Historic England

**SUBMISSIONS AT DEADLINE 9 (25 SEPTEMBER 2019)**

**Highways England for an Order granting Development Consent for the A303  
Amesbury to Berwick Down**

**PINS Reference No: TR010025**

PROPOSED BORED TUNNEL - (WORK No. 1F)

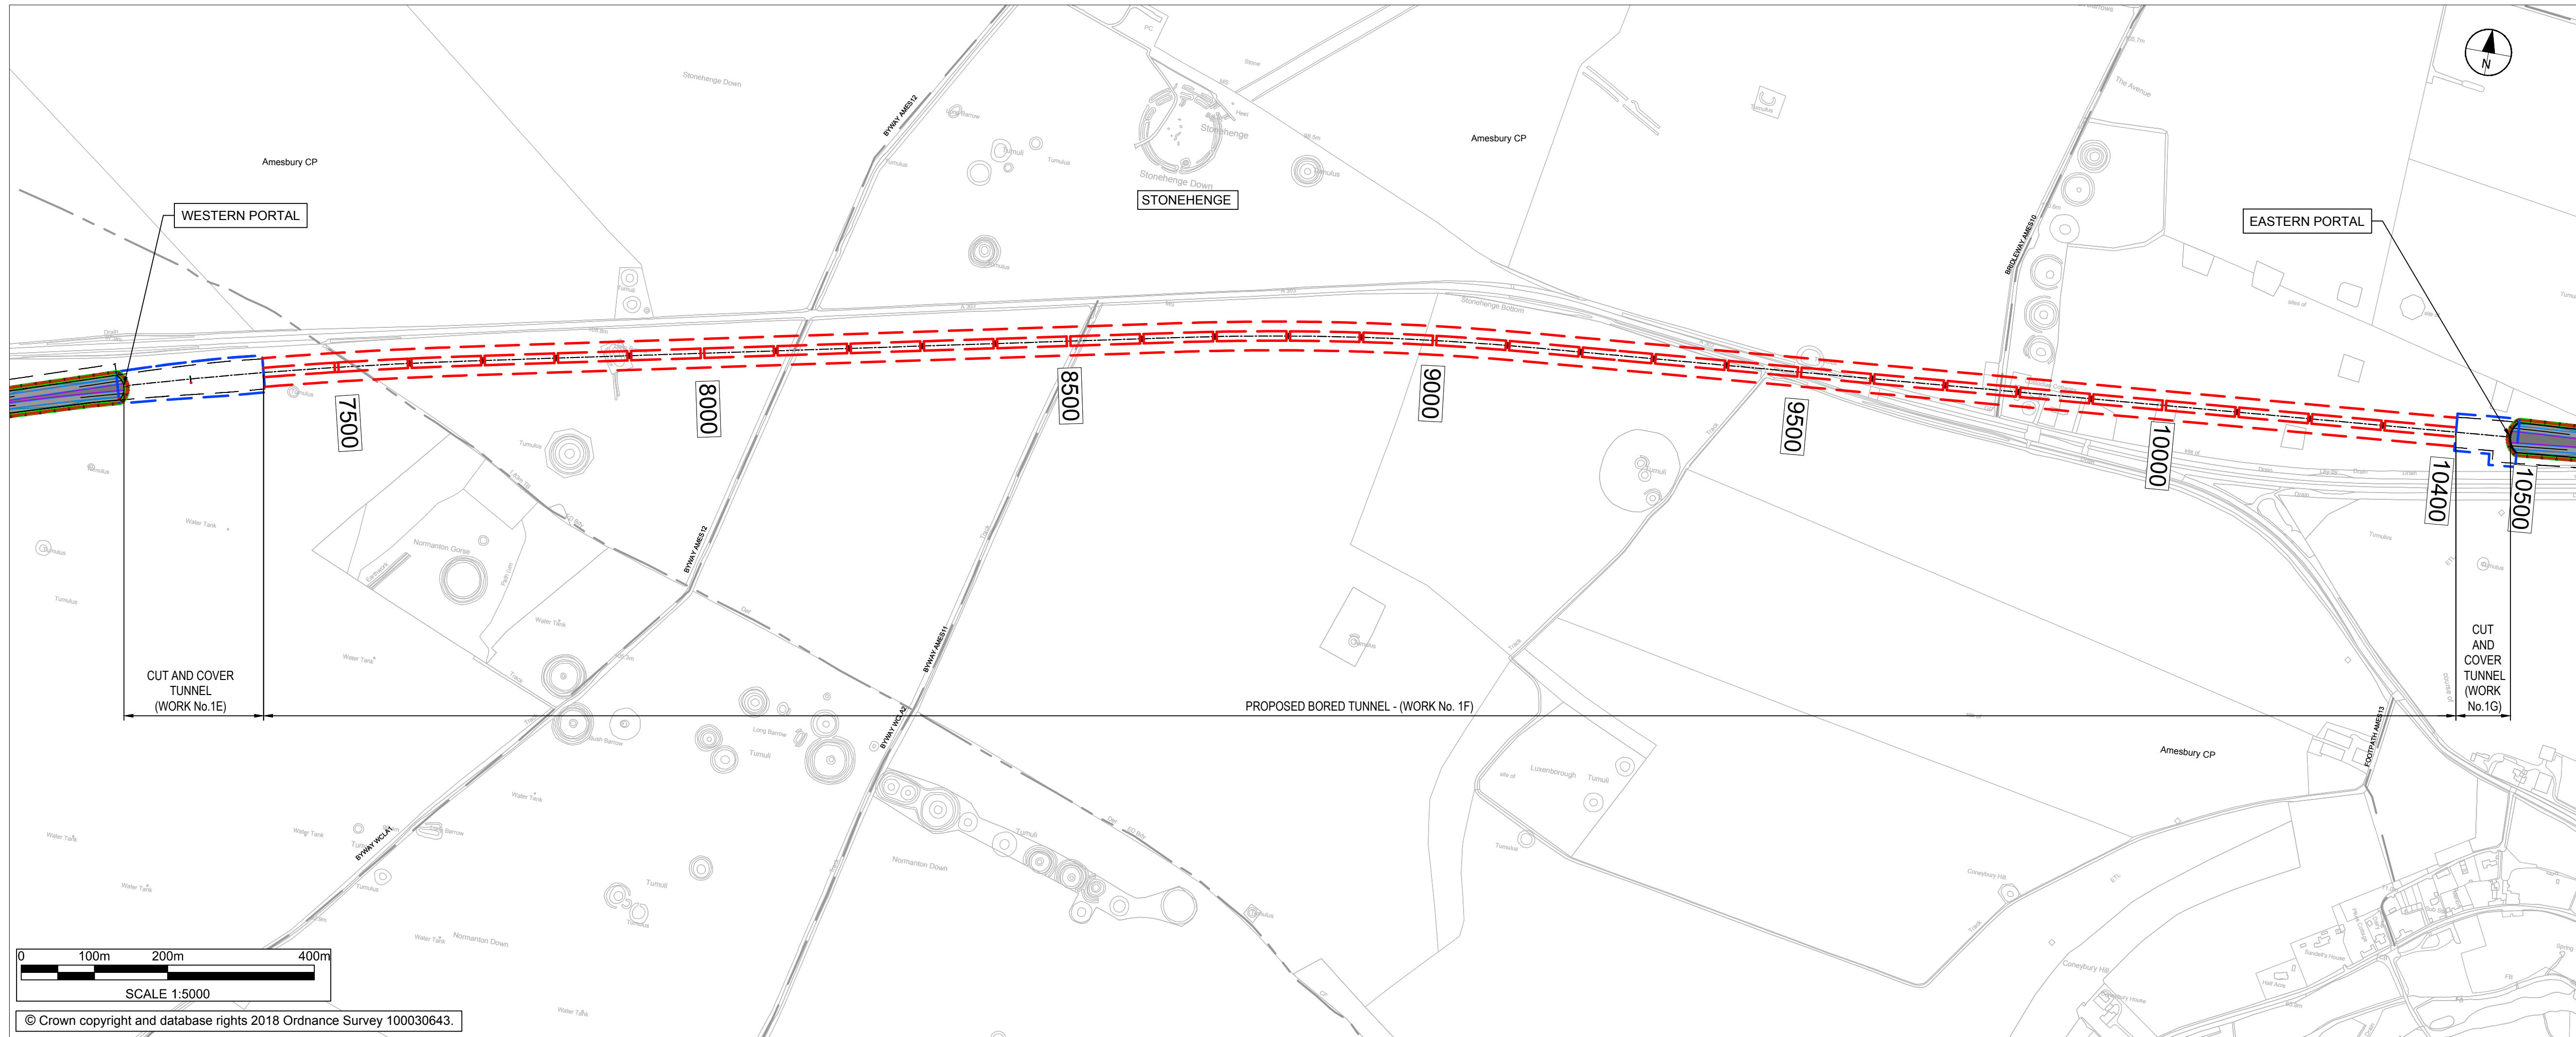
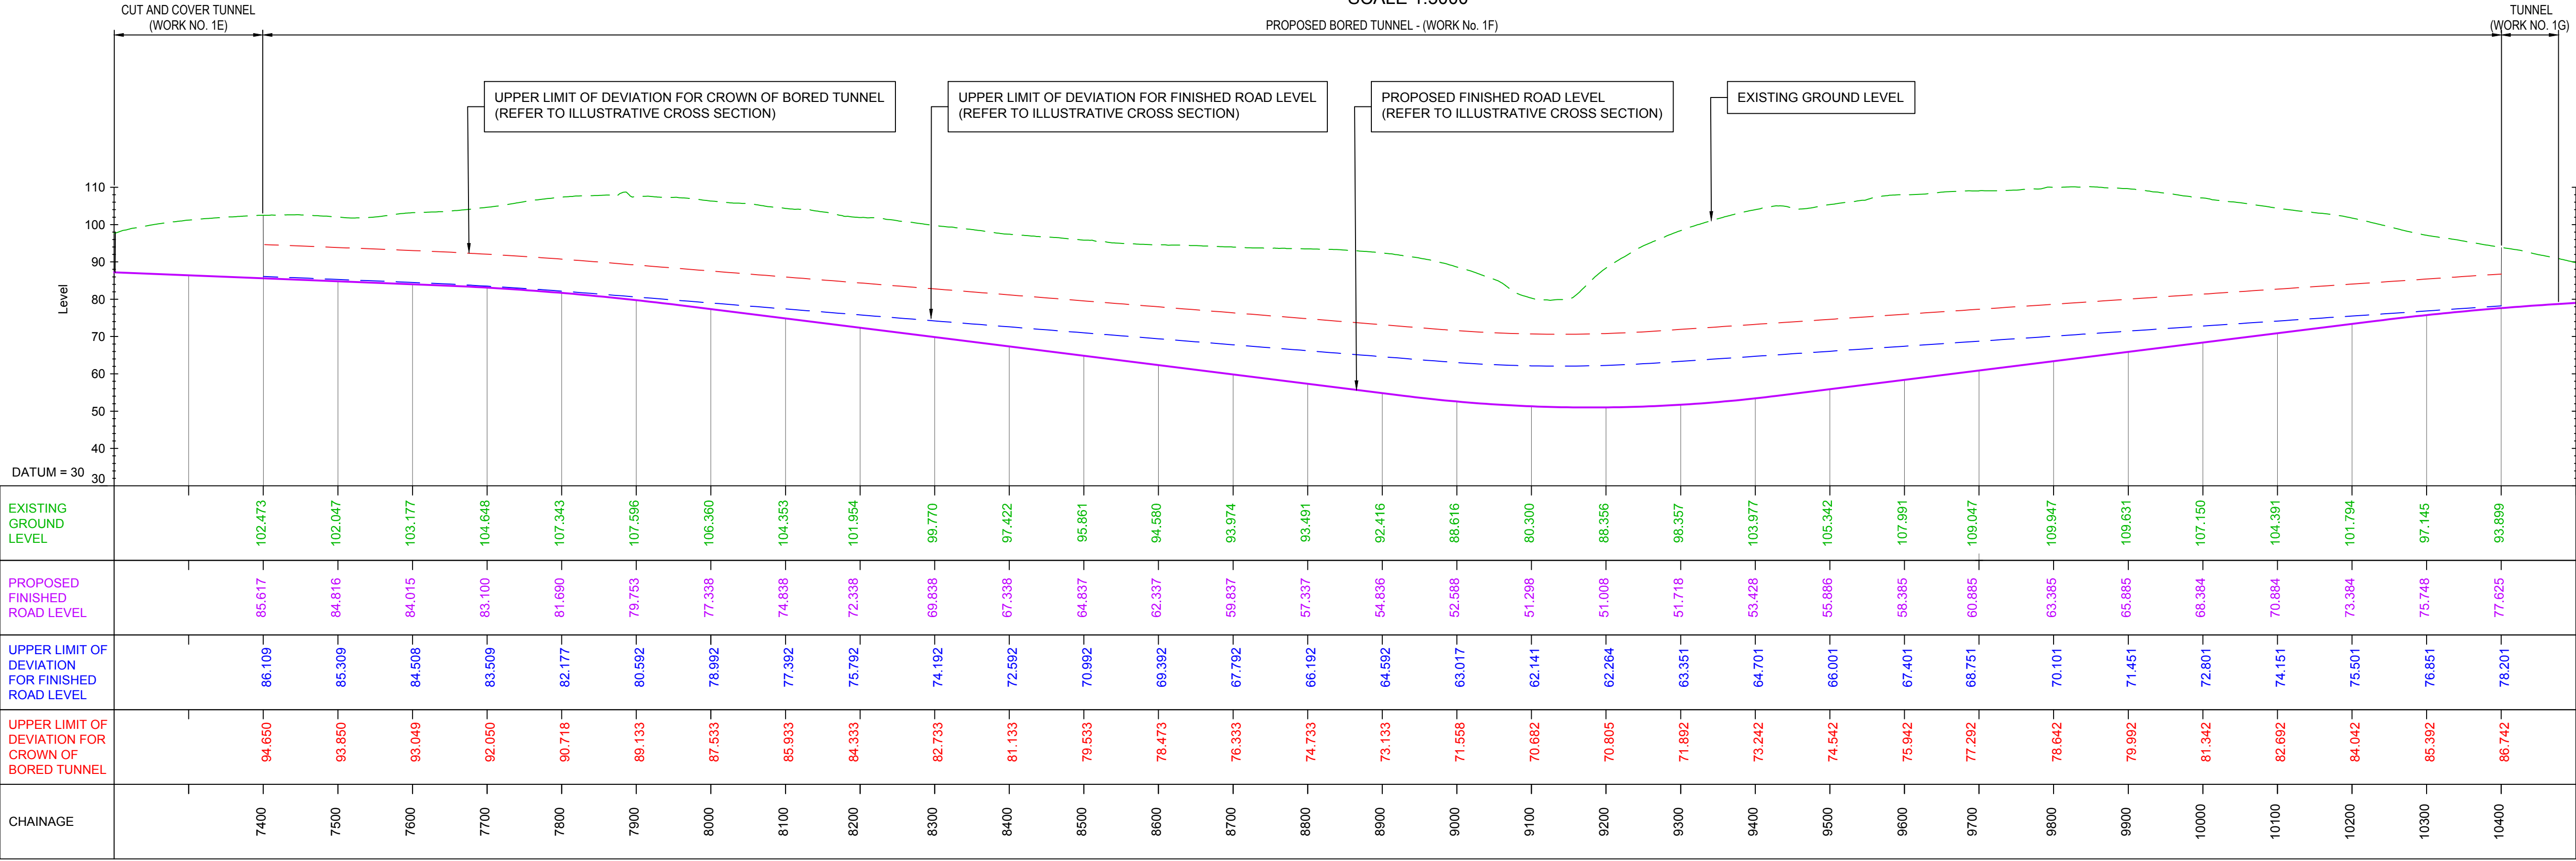
- 3.1.7. The **second** issue is that of vertical limits of deviation and the potential restriction of archaeological research that could take place in the World Heritage Site above the tunnel area<sup>9</sup> which would be contrary to the aims and policies of the SAAS WHS Management Plan (see also section 4 below).

- 3.1.8. Following further discussions with Highways England and the submission of additional information we understand that additional clarification will be set out in the DAMS – a final version of which is to be submitted at Deadline 9.

- 3.1.9. HBMCE considers that Highways England should be in a position to address our concerns with appropriate safeguards in place and sufficient detail being provided for in the DAMS and other associated/consequential documents. This will provide clarity in the procedures to follow for those wishing to undertake archaeological research in the area. We will need to review the final version of the DAMS submitted at Deadline 9 before this can be confirmed.
